**Consultation Response from KC,
Lead Local Flood Authority**

2025/91370 Land at, Gynn Lane, Honley, Holmfirth, HD9 6LF

REVISED AND ADDITIONAL INFORMATION RECEIVED: Demolition of existing dwelling and erection of 50 dwellings with associated access, infrastructure and associated works

Date Responded: 22nd March 2026

Detail
FLOOD ROUTING PLAN

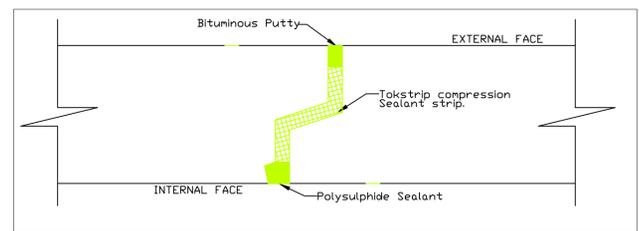
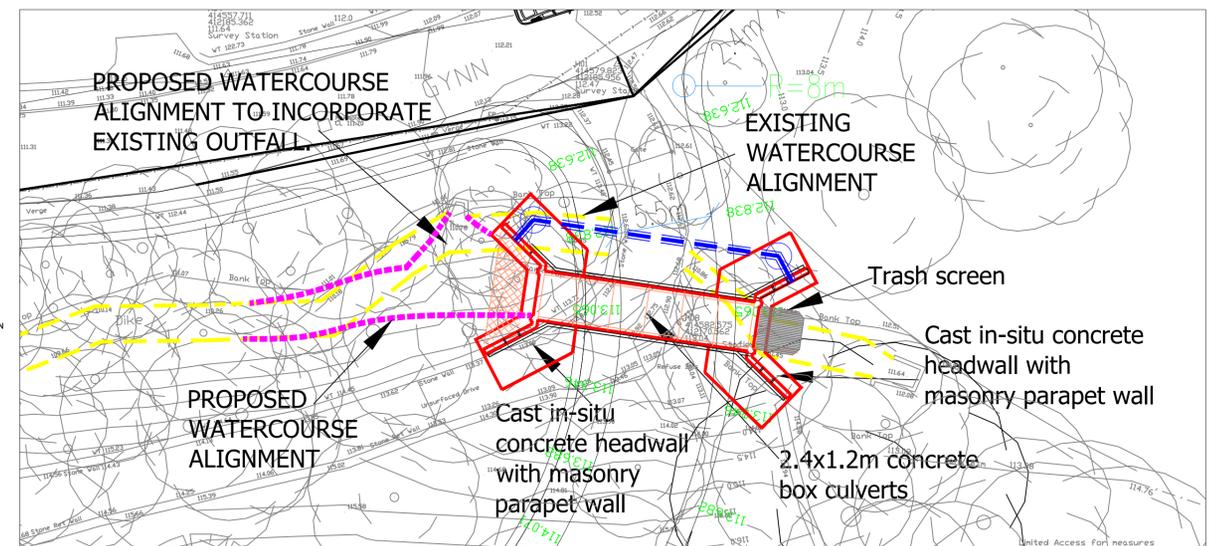
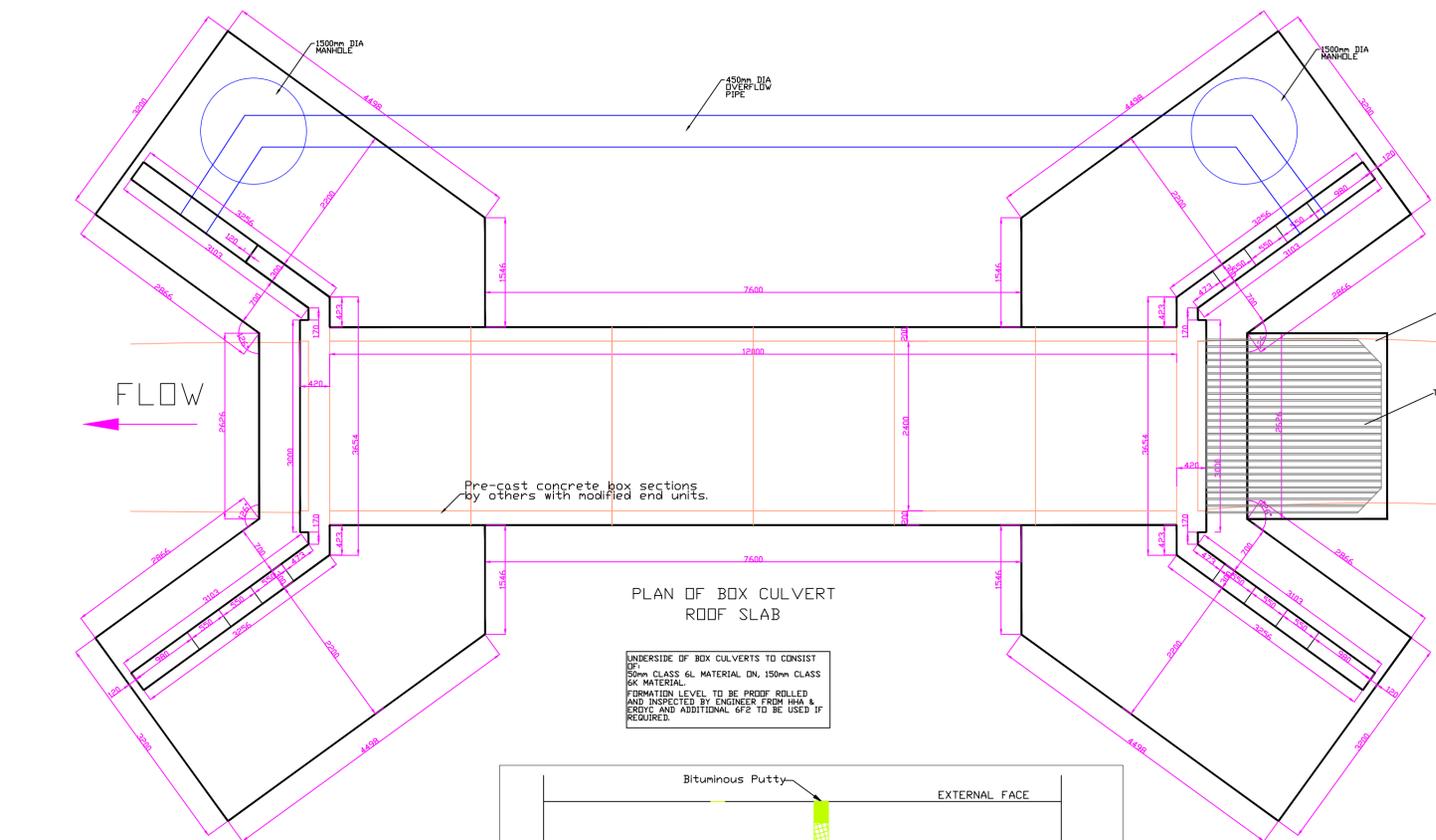
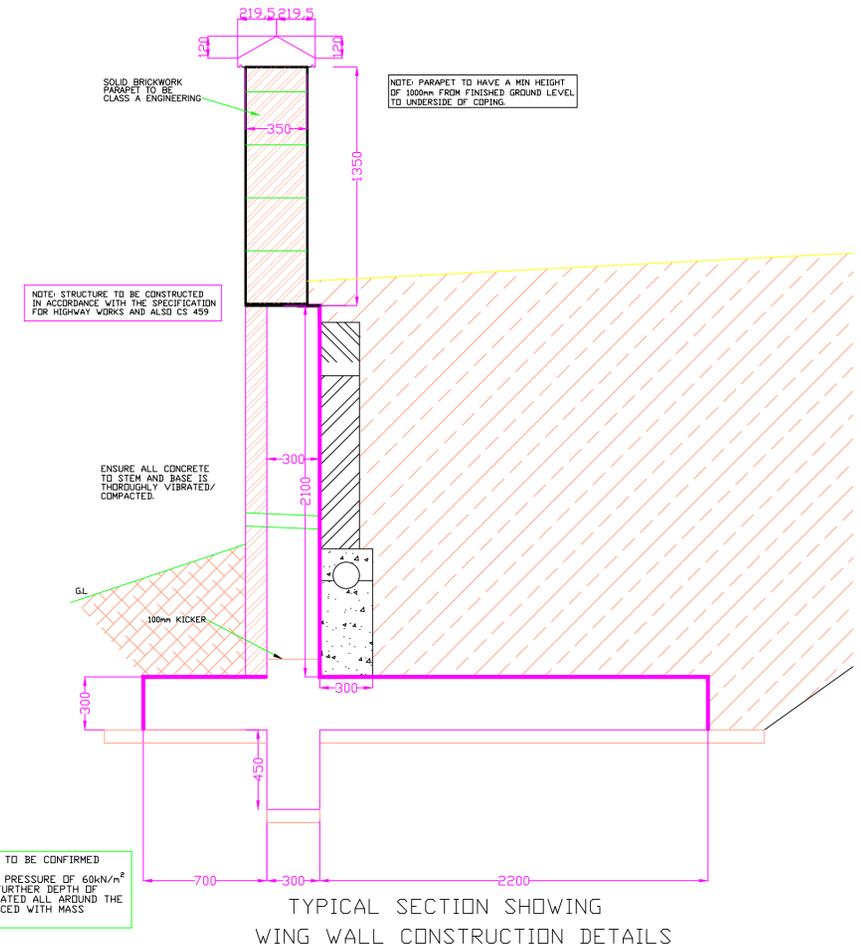
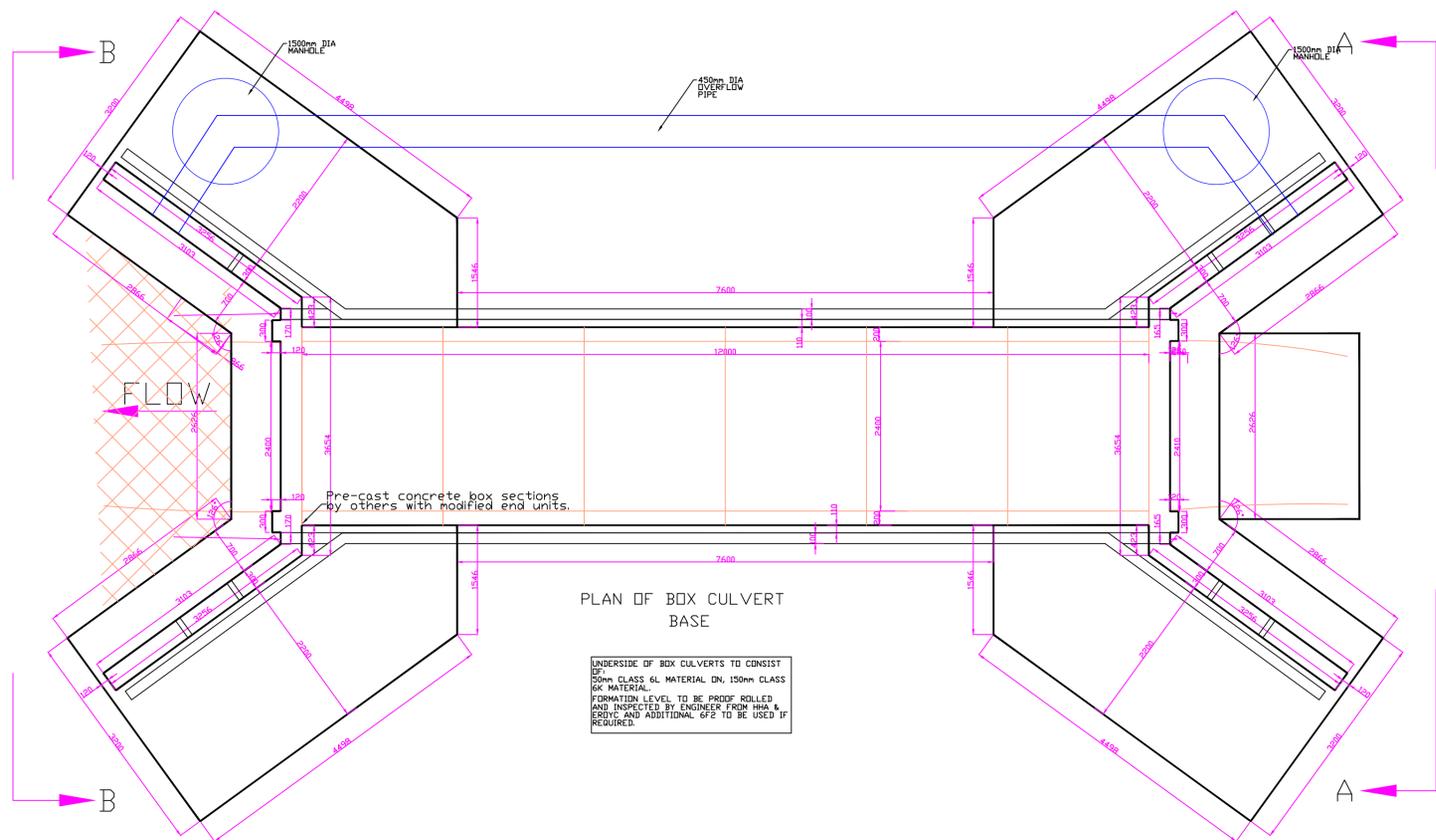
We would like some clarification on flood routing drawings around manhole S9 where a private drive is shown as is a continued pavement. Flows need to be directed along the main estate highway and the private drive isolated from main flow routes. We would accept isolated flow routes as shown on the private drive.

Detail
 ROAD 1 CULVERT/HEADWALL CONSTRUCTION DETAILS (DRAWING 10F2)

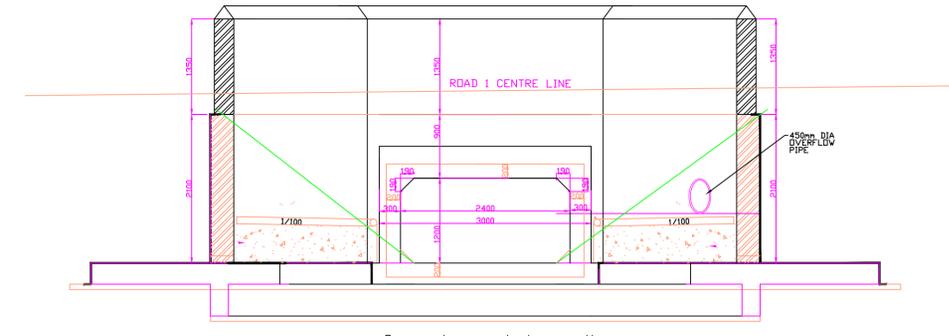
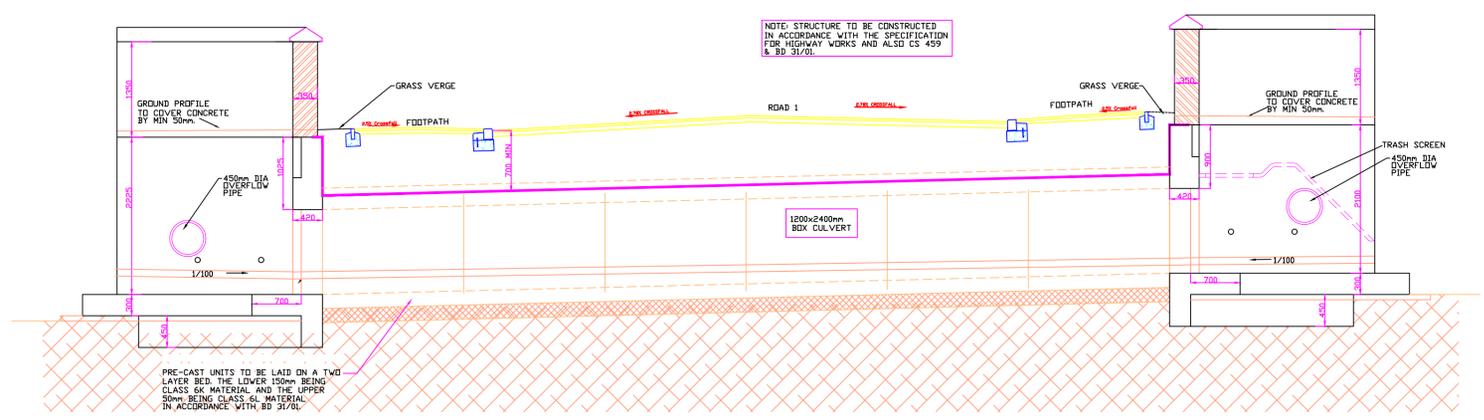
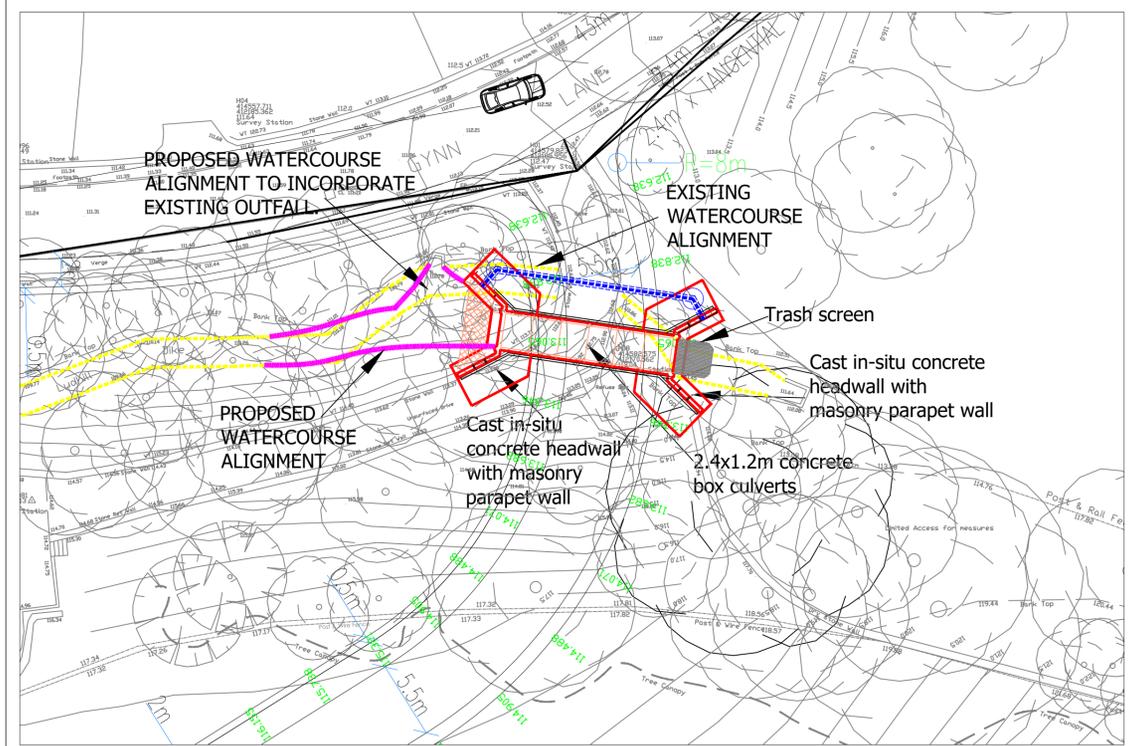
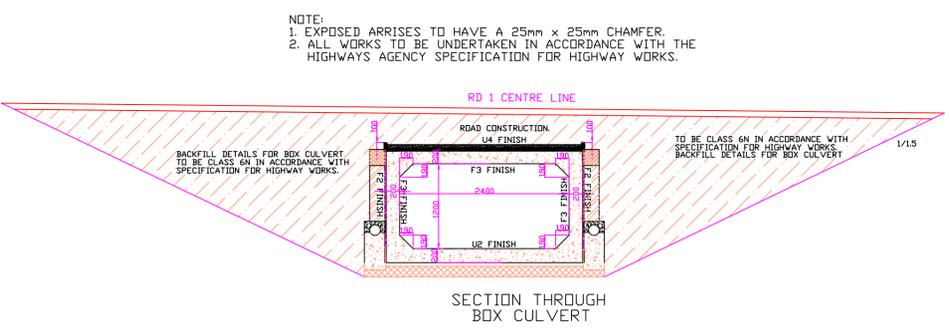
- Potential issues around plots 32 and 33 have been addressed.
- A blockage scenario is currently a potential risk in theory under where the site entrance is proposed. The culvert is to be realigned to reduce the risk immediately downstream.
- A trash screen has been proposed, and this can be determined under condition. However, a high-level overflow reduces risk of flooding and is accepted.
- Additional drainage is proposed on Gynn Lane to benefit a return to Ludhill Dike of flood waters generated by overflow of watercourses and sewer surcharges.
- Double storm gullies are to be installed either side of the bridge.
